**From:** Tim Screen <[Tim.Screen@cherwellandsouthnorthants.gov.uk](mailto:Tim.Screen@cherwellandsouthnorthants.gov.uk)>  
**Sent:** 14 June 2019 10:27  
**To:** Caroline Ford <[Caroline.Ford@cherwellandsouthnorthants.gov.uk](mailto:Caroline.Ford@cherwellandsouthnorthants.gov.uk)>  
**Subject:** RE: 19/00155/DISC - Bicester Eco Town Exemplar Site

Re River Corridor Planting Plan AL6157C 3903

AL6157C_3904 **REV -**
INFORMATION

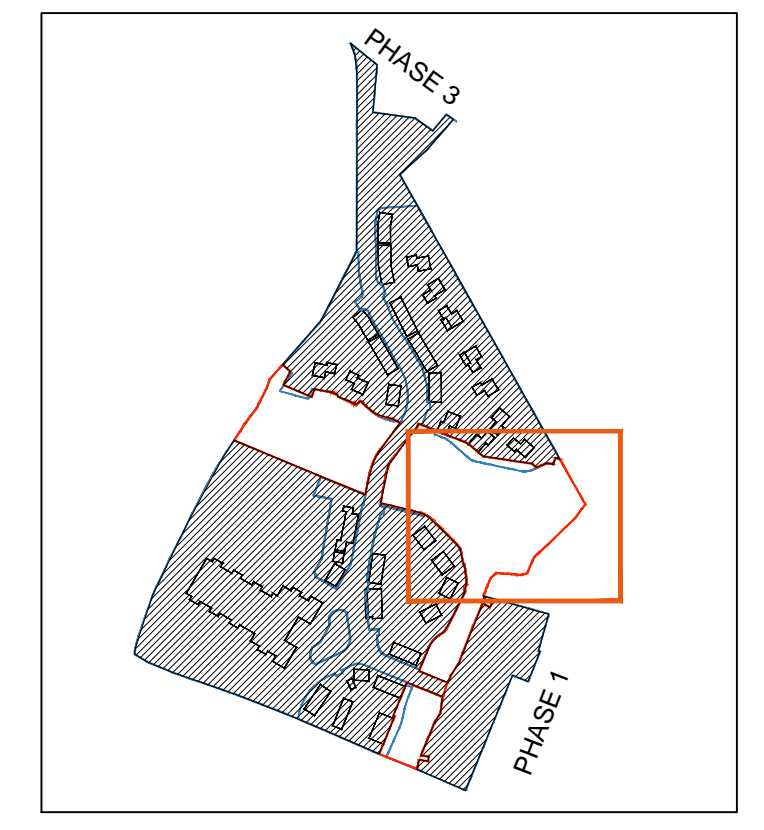
1. Include two Black Poplars, *Populus nigra*: one to be planted in the north area, in the middle of the proposed tree groups, at a distance 28 m due west from the corner of the application boundary – a plan can be marked up to explain. The other *P. n.* is to be planted to replace the single *Alnus glutinosa* west of the large area of thicket.

2. The flood risk area is to be considered (overlaid over the planting plan) to ascertain whether the following trees are caught within the flood envelop: *Acer campestre*, *Fagus sylvatica* and *Quercus robur*. The trees may suffer with poor establishment due to the soil moisture content being too high, especially with flooding. I there recommend that the these trees are replaced with trees that are more able cope with these conditions, *Populus alba* and *Populus tremula*.

3. The thicket shrub species must also be appropriate to wetter areas of the river corridor, for instance *Ilex*, *Quercus*, *Acer*, *Prunus avium*, *Rosa*, *Corylus*, *Malus sylvestris* and *Ligustrum* are not going to survive high moisture levels and flooding. Willow species should be included in the mix: *Salix caprea*, and *S. viminalis*.are to provide the variety of species in these locations. *Prunus spinosa* is acceptable.

4. On the drier areas above the flood area the originally proposed mix is acceptable, with the inclusion of *Euonymus europaeus*.

**AL6157C\_3905** **REV -**  
**INFORMATION**

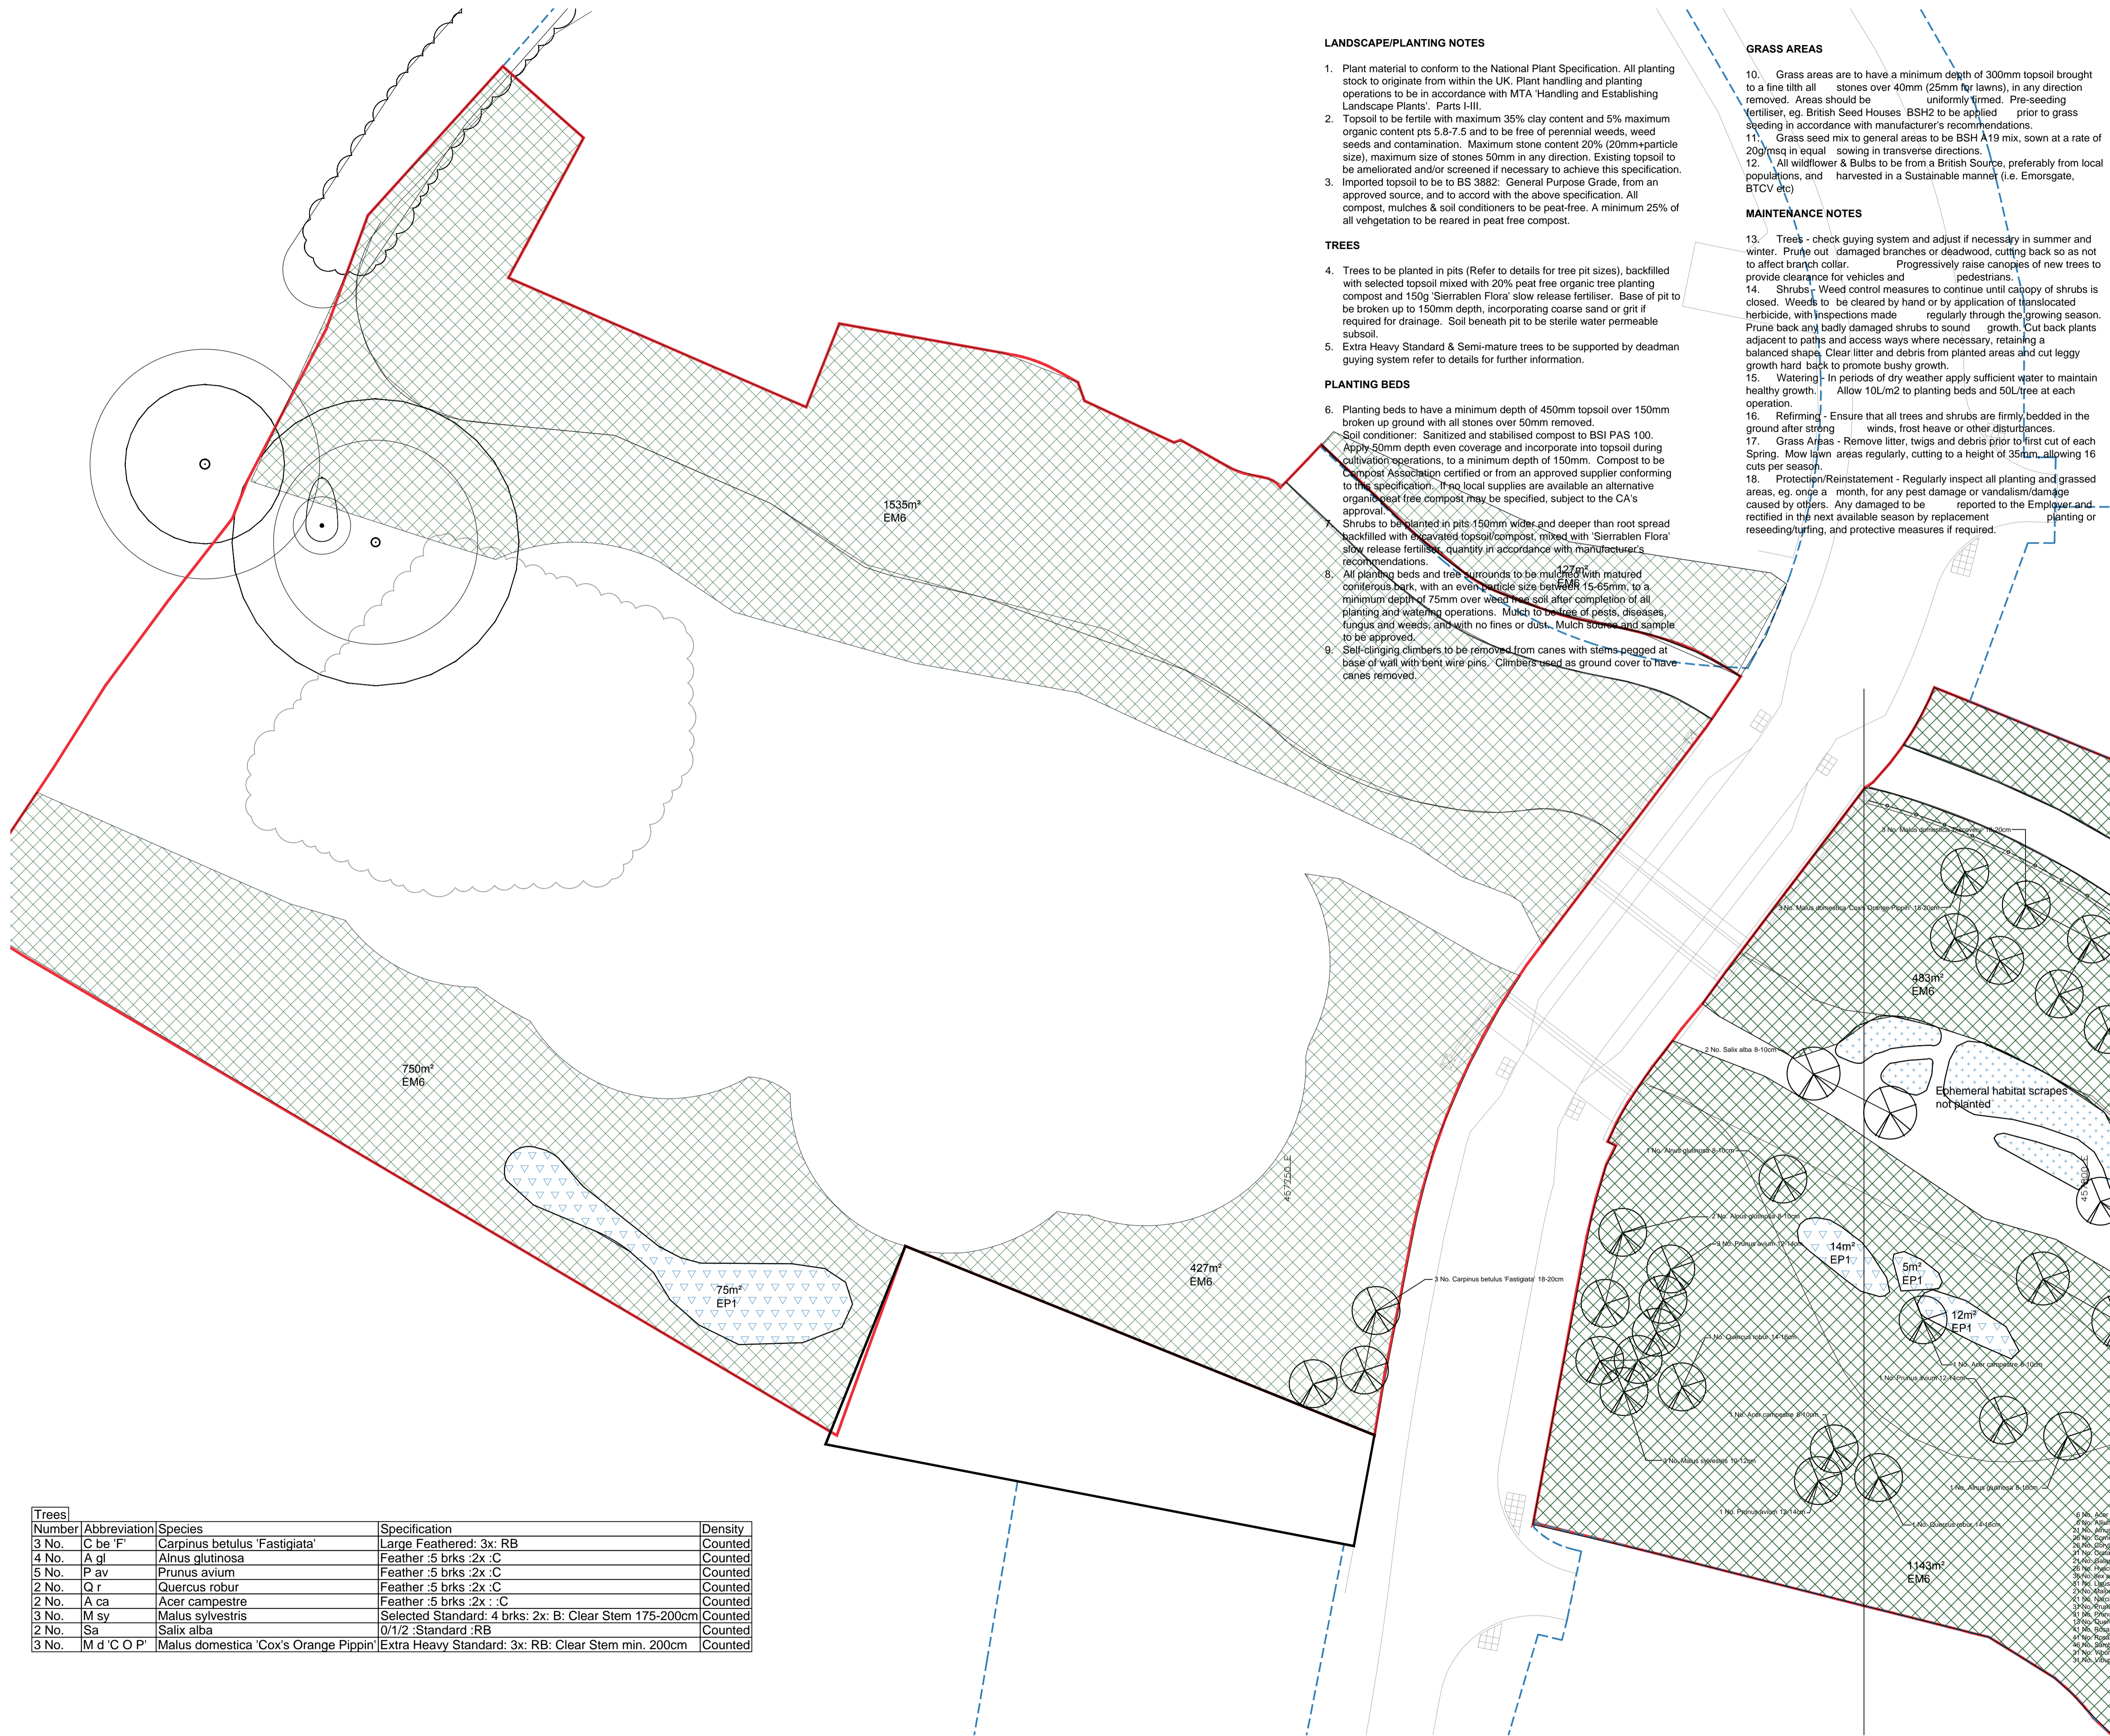
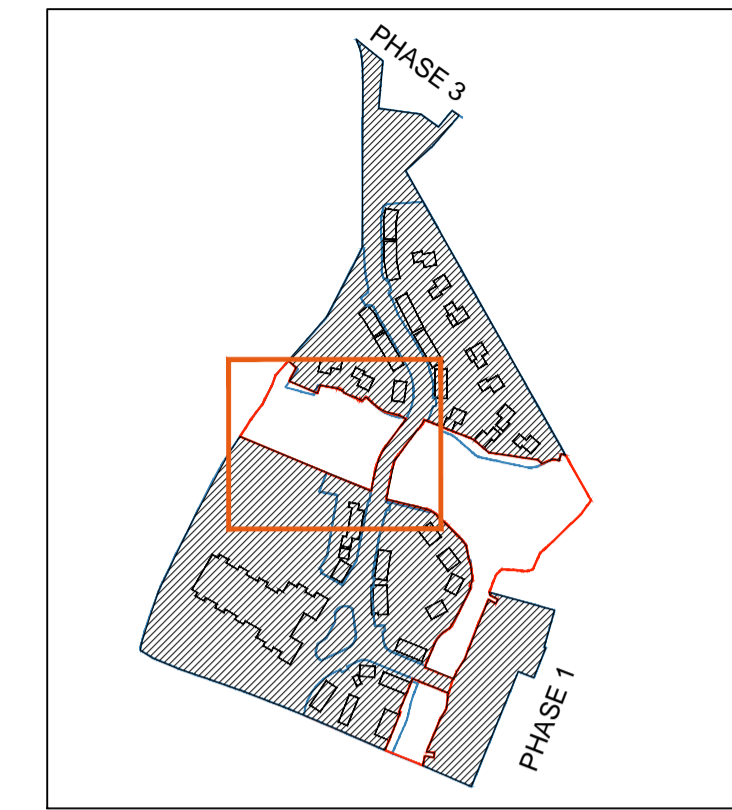
1. A clarification on the landscape treatment of the rectangular space between the school's northern boundary and the river corridor is required.

2. The school's northern boundary requires a native hedgerow to be planted for visual amenity – details to be indicated on the planting plan.

AL6157C_3903 **REV -**
INFORMATION

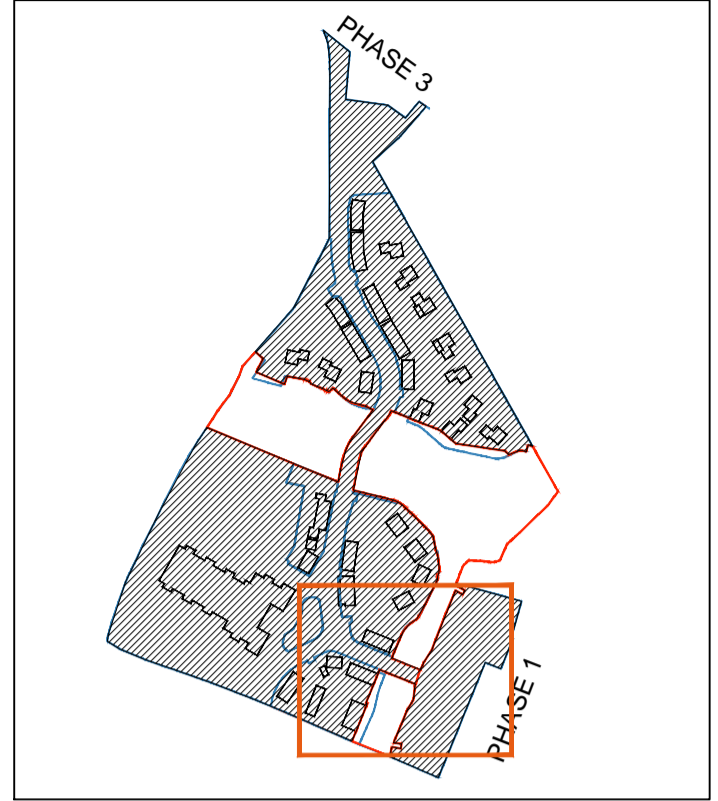
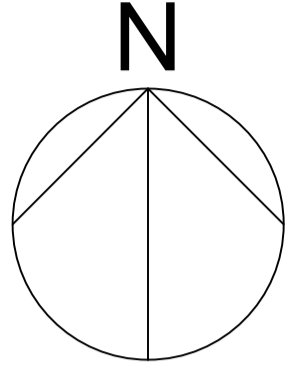
1. Existing river corridor trees and structural vegetation must be indicated on the drawing to inform the context of the proposed landscaping.
2. The area south of the bridge requires clear, unobstructed maintenance access: to be clarified by indication on the drawing.
3. The 2 no *Acer campestre* trees are located in an area that will be quite wet, at the base of the embankment and near the stream where it floods. Therefore replace these trees with 3 no *Salix caprea*. For species diversity and amenity the two *Salix alba* should be replaced with 3 native alder *Alnus glutinosa*.
4. Delete the lone *Malus sylvestris* from the embankment because it will be difficult to establish on a dry banks and will be damaged by the mower/trimmer. Include a group of 3 *Salix alba* north of the bridge.
